# Planning Inspectorate NSIP ref no TR010037

## A47 – A11 Thickthorn Junction

Submission from Richard Hawker IP ref No 20028387 Date: 3 March 2022

### Deadline D8 comments

### Potential solutions for Cantley Lane South

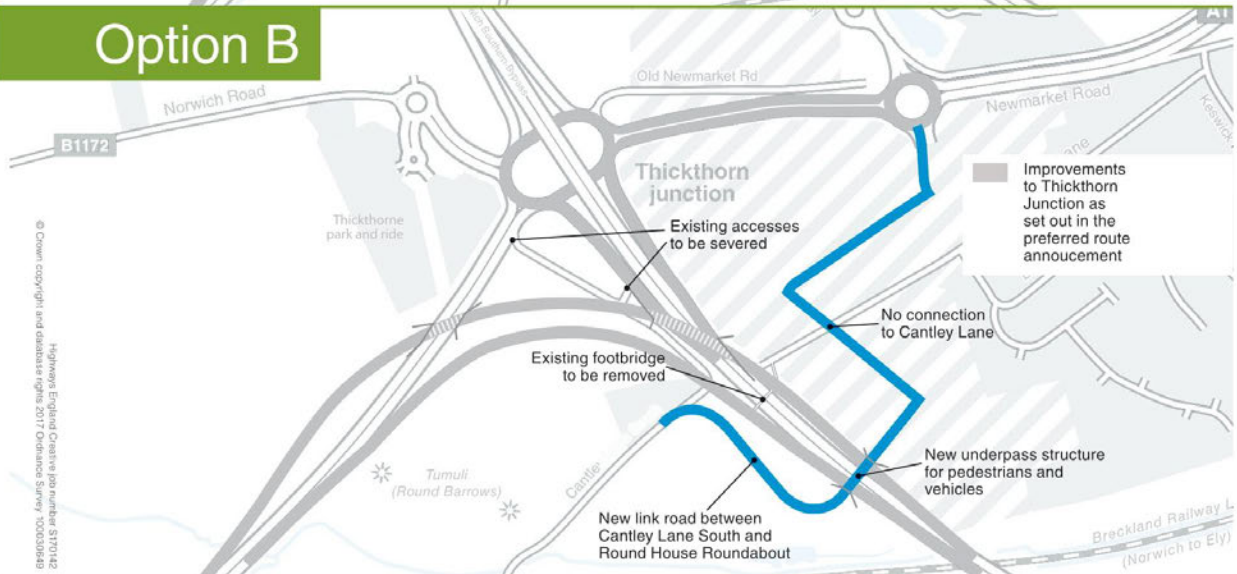
The applicant, in REP7-007, refers me to the accident data in APP-125, section 4.12. This was in response to my asking about accident occurrences in the slip road arrangement for A47NW to A11SW, (where the feed from Cantley Lane joins the slip) in the absence of information from the applicant to explain in what way this slip road arrangement was no longer acceptable, and why no acceptable redesign could be contemplated in that local area.

- a) convinced that there is no safe way of allowing Cantley Lane residents to gain access to the main road system without the expense and environmental disruption of the new road over the A11
- b) assured that the £7.2M saving over 60 years due to accident reduction is valid
